Our Case Number: ABP-316119-23

Re: DART+ South West Electrified Heavy Railway Order - Hazelhatch & Celbridge Station to Heuston Station, and Hesuton Station to Glasnevin
County Dublin and County Kildare

**Property: Kilmainham Square Mixed-Use Development of
231 Units (The Chocolate Factory Property
Management Company Ltd. By Guarantee)**

**Submission to the Draft Railway Order
[DART+ South West Electrified Heavy
Railway Order 2023]**

Project Title	Client	Plan No.
10.11.22	Scale N.T.S. @ A3 1:1250 @ A0	Works Layout Plan No. 13
Date	Scale	Client
10.11.22	N.T.S. @ A3 1:1250 @ A0	lanród Éireann Irish Rail
Drawn	Checked	Approved
RG	DM	DM
DO NOT SCALE USE FIGURED DIMENSIONS ONLY

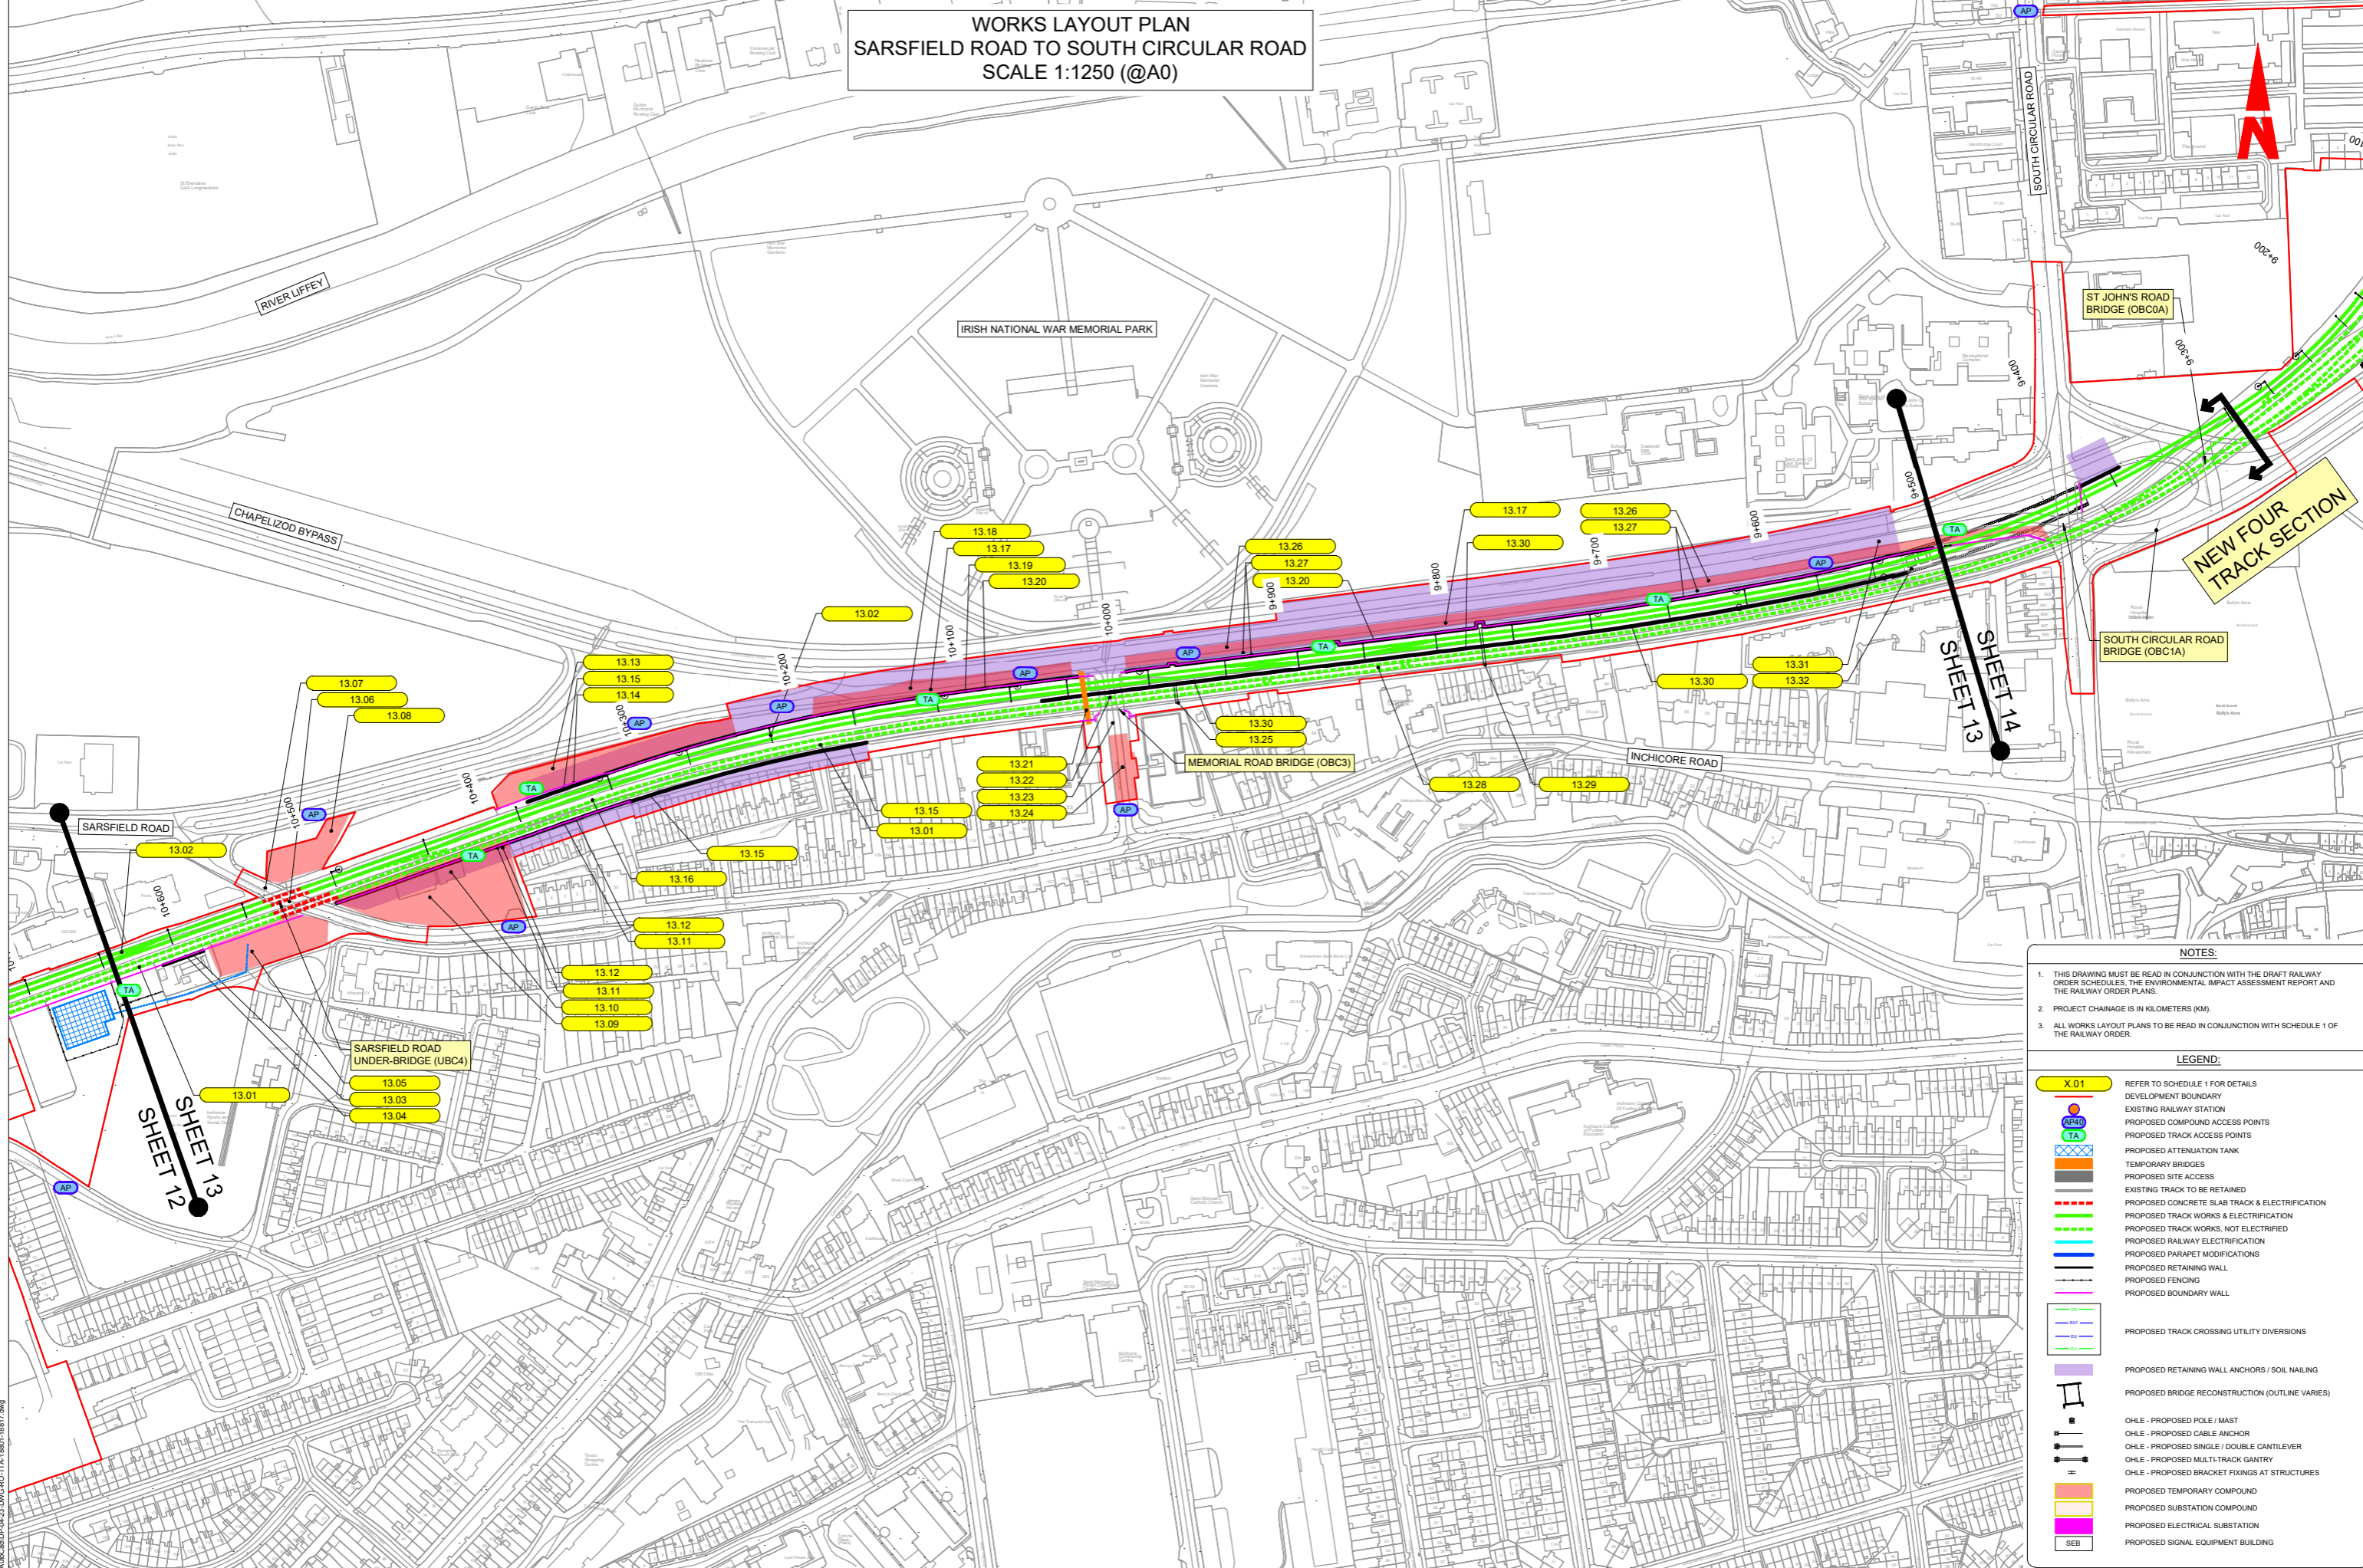
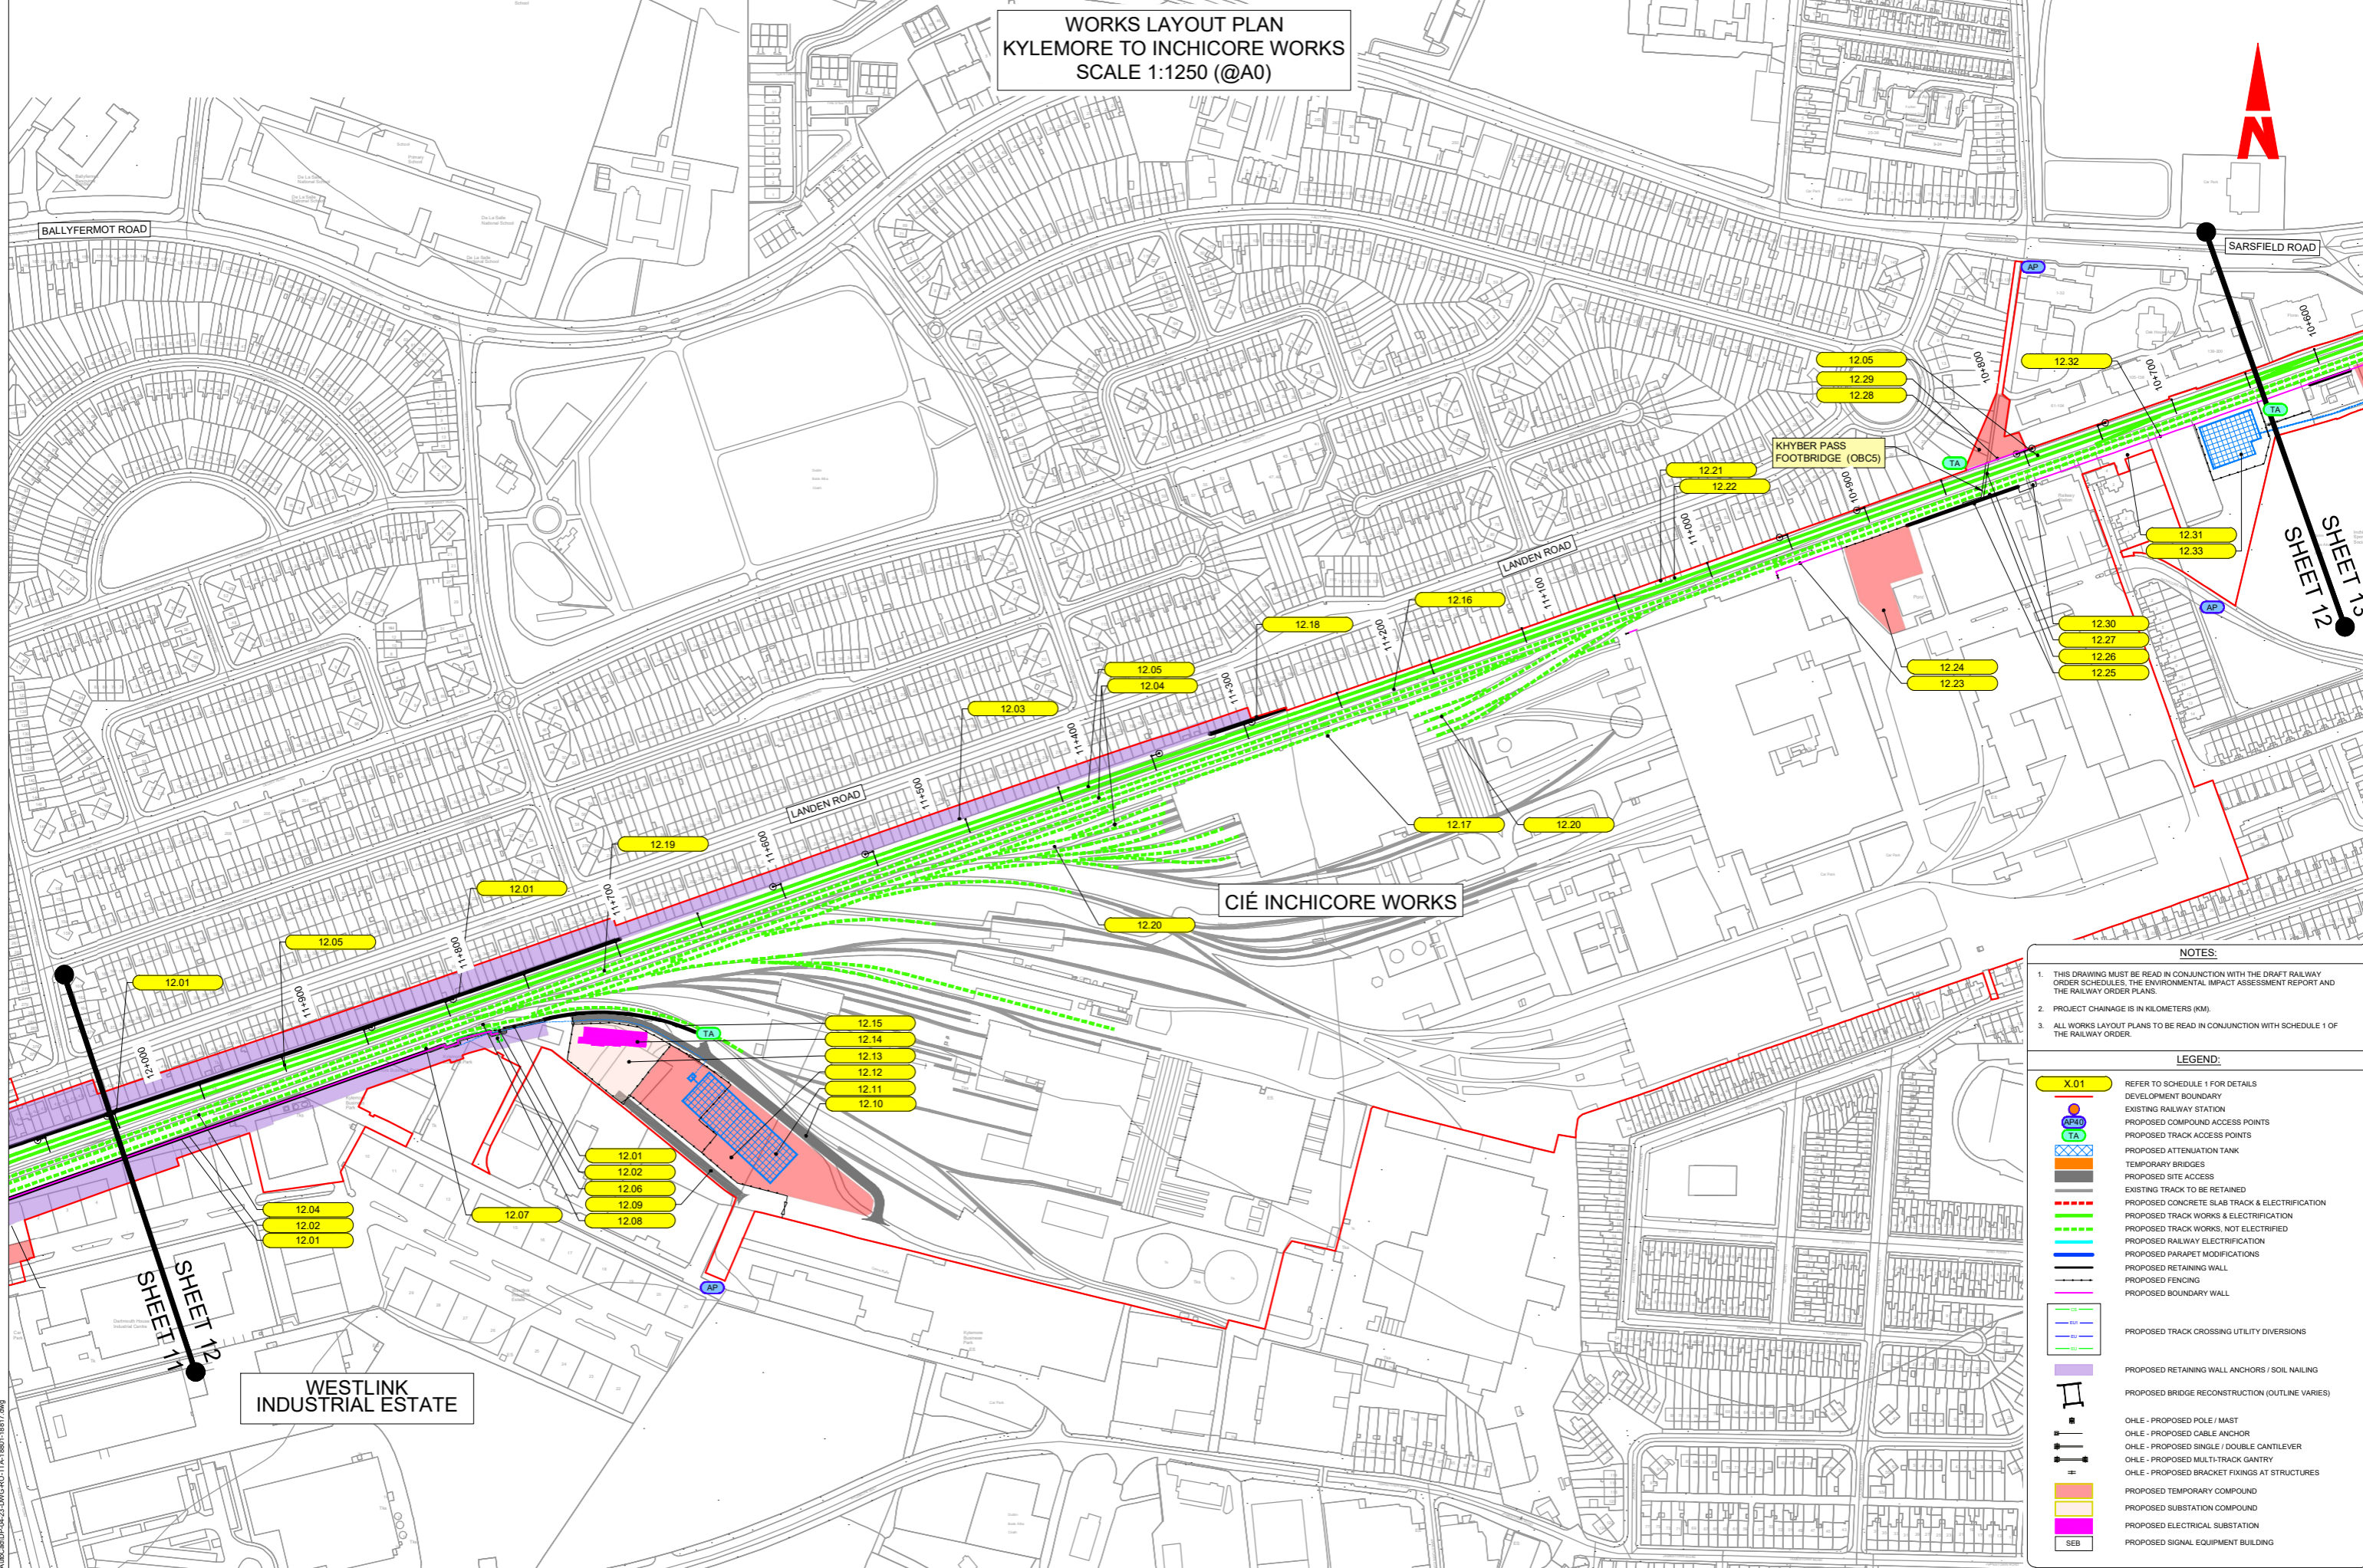
The DART+ South West railway bounds the northern boundary of the Kilmainham Square Apartments, passing approximately 7m from the front of the apartment blocks. The works layout plan in relation to the site has been specified on the drawing Site Layout Plan No. 13, Book 1 of the Order drawings.

As marked up on the drawing, work planned at this section of the road involves proposed track works for electrified and not electrified extension of the railway (green continuous and dashed line respectively), as well as a proposed retaining wall to the northern boundary of the railway casement.

the junction with associated lane marking. The works will entail extensive temporary traffic management measures, including lane diversions and temporary lane closures and temporary and permanent utility diversions" (work detail no. 13.31 on the drawing).

Moreover, there is "installation of a new 'cut-and-cover' buried portal structure (OBC1A) to accommodate two new railway tracks and electrification of same. This will include piling of the portal abutments under the road section. Construction of the roof slab elements, waterproofing and backfilling over the structure. All parapets and corridor boundary walls affected will be reconstructed over the new structure. A pedestrian access point (for maintenance) will be created from a new maintenance parking platform on the structure" (work detail no. 13.32 on the drawing).

All works will be facilitated via a temporary compound located to the northern boundary of the railway casement that is highlighted in red on the drawing.
